RE: Oxley Solar Farm (SSD-10346) Armidale Regional Council

Attachment 1: Detailed BCD Comments – Oxley Solar Farm (SSD-10346)

Biodiversity Development Assessment Report

Figure 3-1 Category 1 land excluded from the BAM assessment

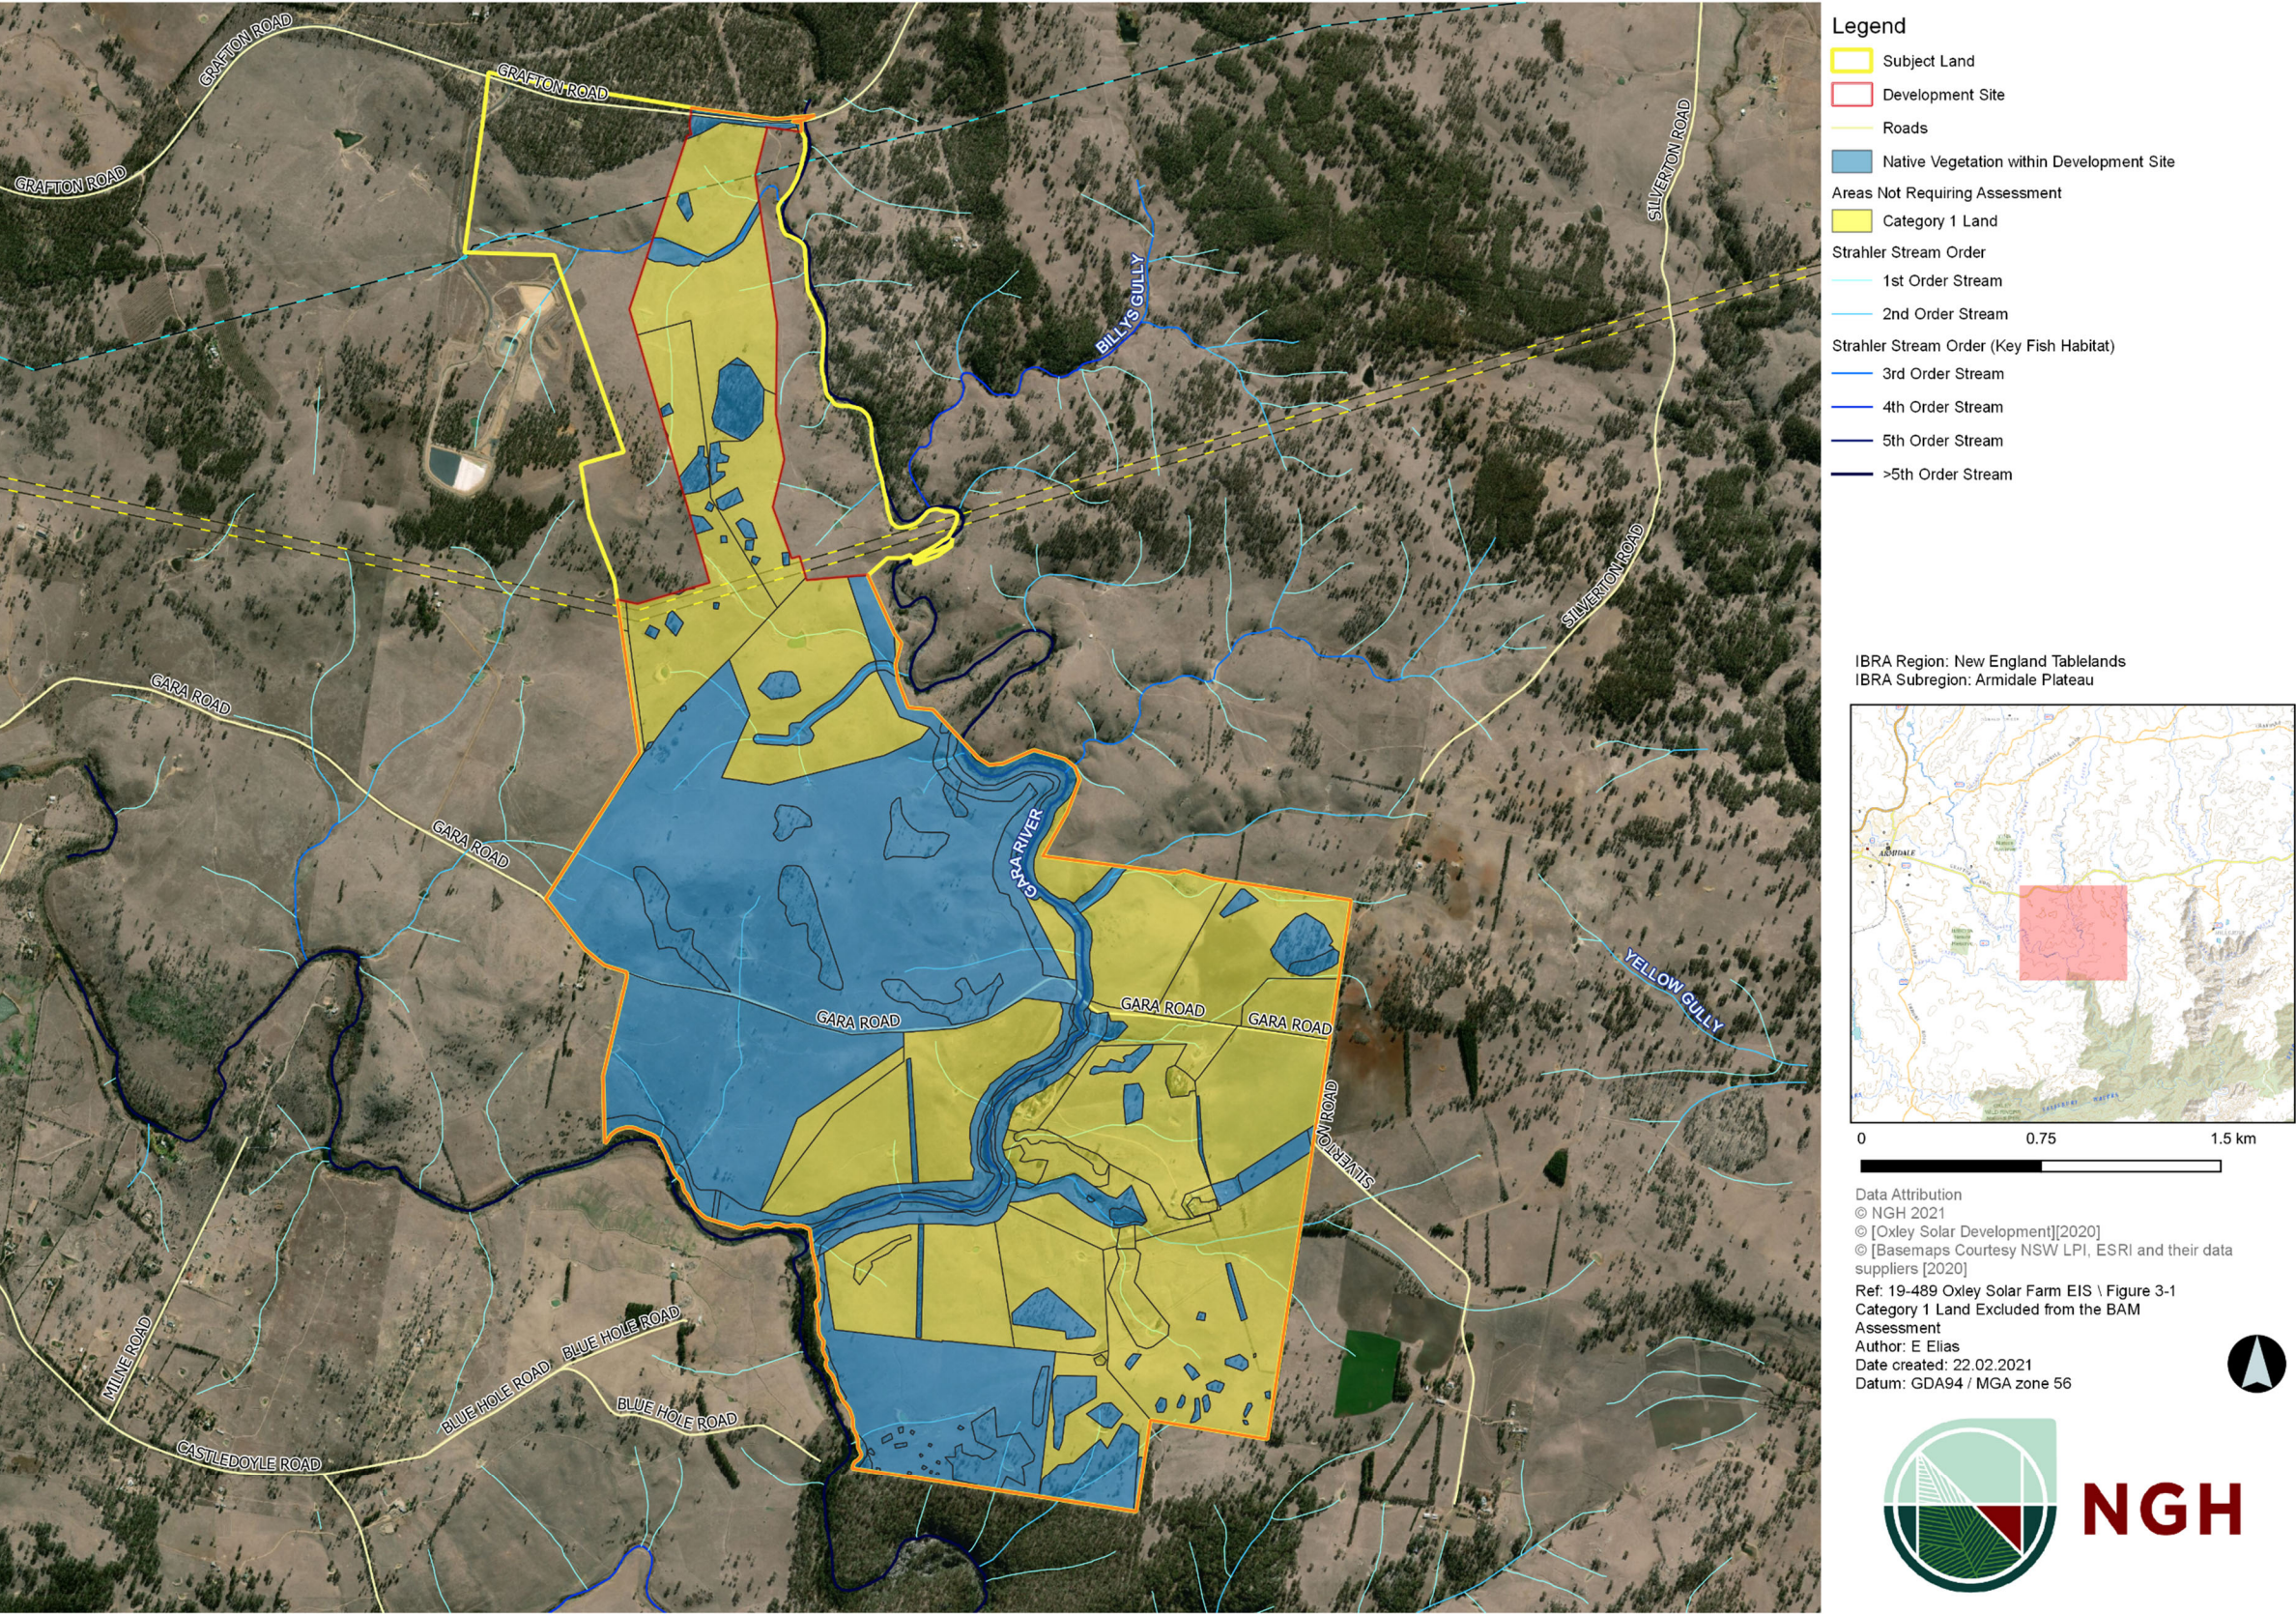
A Category 1 exempt land assessment has been undertaken for the site as shown in figure 3-1 of the BDAR. As stated in s6.8(3) of the *Biodiversity Conservation Act 2016* (BC Act), the biodiversity assessment is to exclude the assessment of any clearing of native vegetation and loss of habitat on category 1-exempt land, other than the additional biodiversity impacts in accordance with clause 6.1 of the BC regulation.

The Remote Sensing and Regulatory Mapping Team of the Department of Planning Industry and Environment has reviewed the NGH land categorisation mapping for the site against the relevant legislative provisions. Although there is large agreement with the NGH categorisation, the Department has identified an area which has been mapped by NGH as Category 1 exempt land that should instead be mapped as Category 2 regulated land. The NGH land categorisation mapping, as shown below, identified the area between Gara Road and the Gara River as Category 1 exempt land (yellow). However, the Department's assessment found that no non-woody disturbance could be detected via aerial imagery in this area between 1990 and 2017. Accordingly, this area needs to be assessed as Category 2 regulated land.

2. The BDAR must be updated to assess the area between Gara Road and the Gara River as Category 2 regulated land.

Figure 7-1 Indirect impact zone

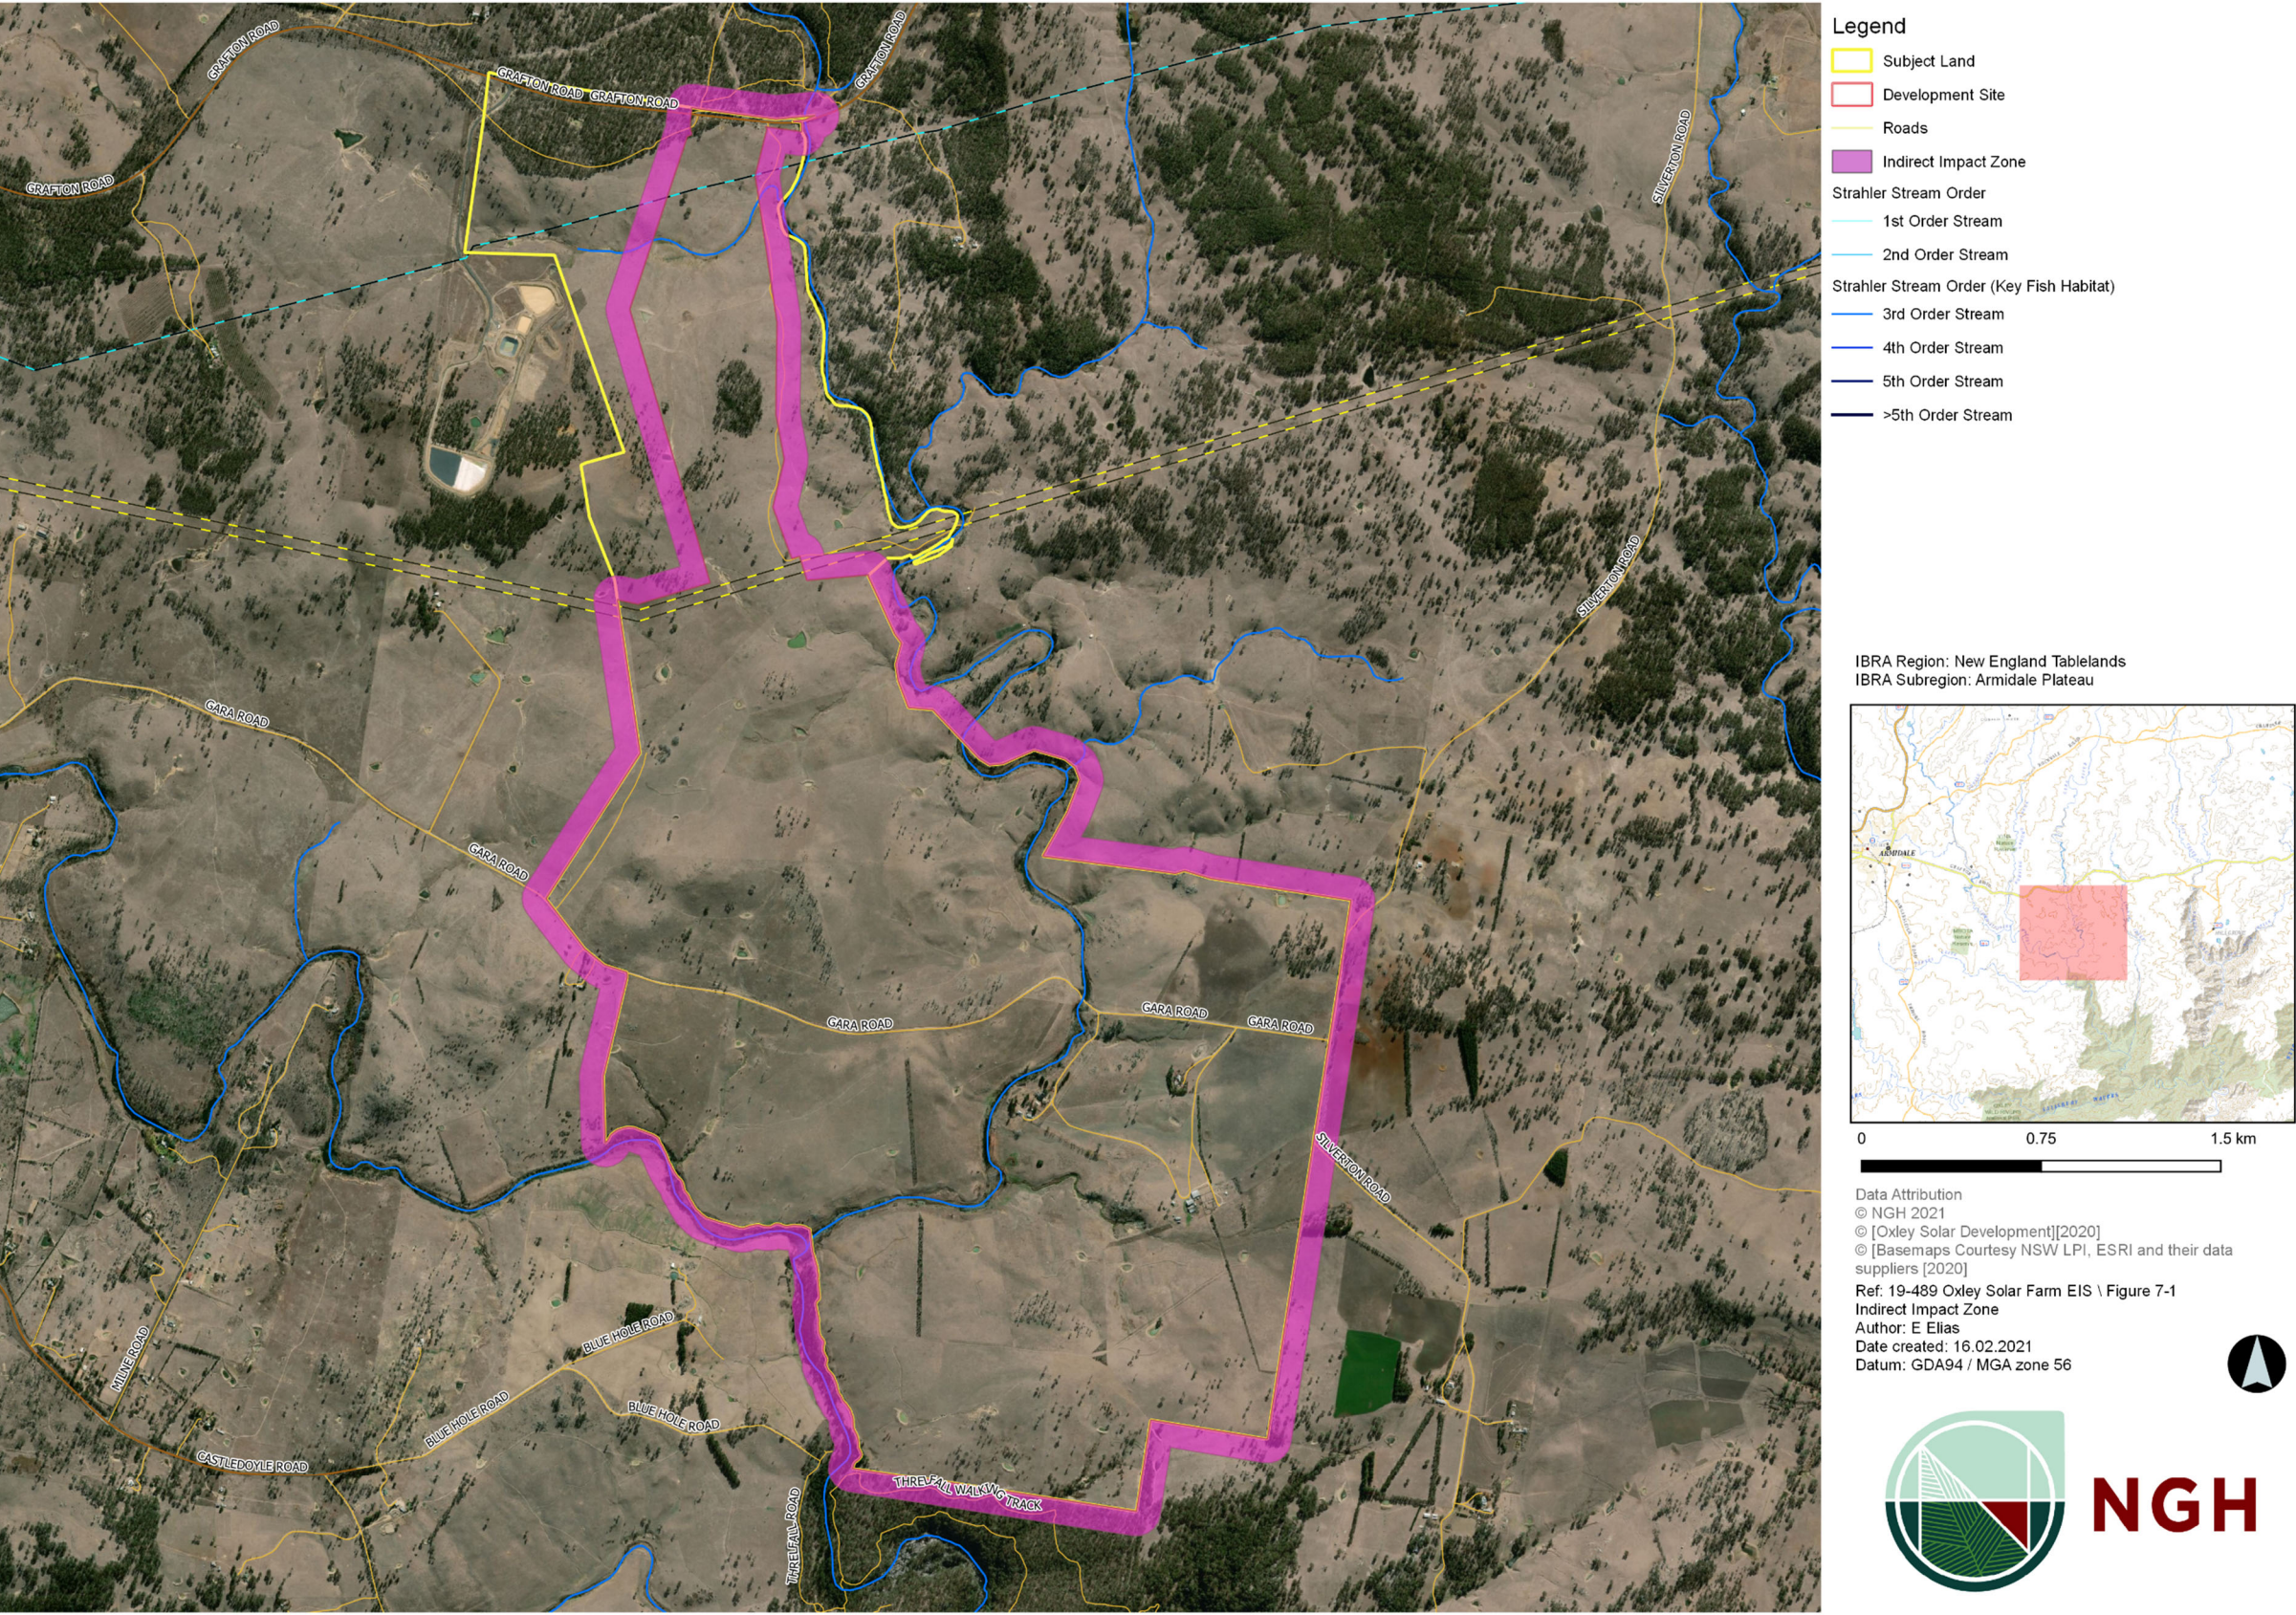
Figure 7-1 of the BDAR shows the mapped indirect impact area of the proposal as shown shaded pink below.

Table 7-5 of the BDAR describes the types of indirect impacts that may occur from the development. Some of these indirect impacts may extend to outside the subject site, however the main consideration of the indirect impact zone should be focused to the area immediately adjacent to the development footprint, such as solar arrays, access tracks and other infrastructure.

4. Further consideration must be given in the BDAR to identifying indirect impacts immediately adjacent to the development footprint and determining whether biodiversity credits are required to offset these impacts.
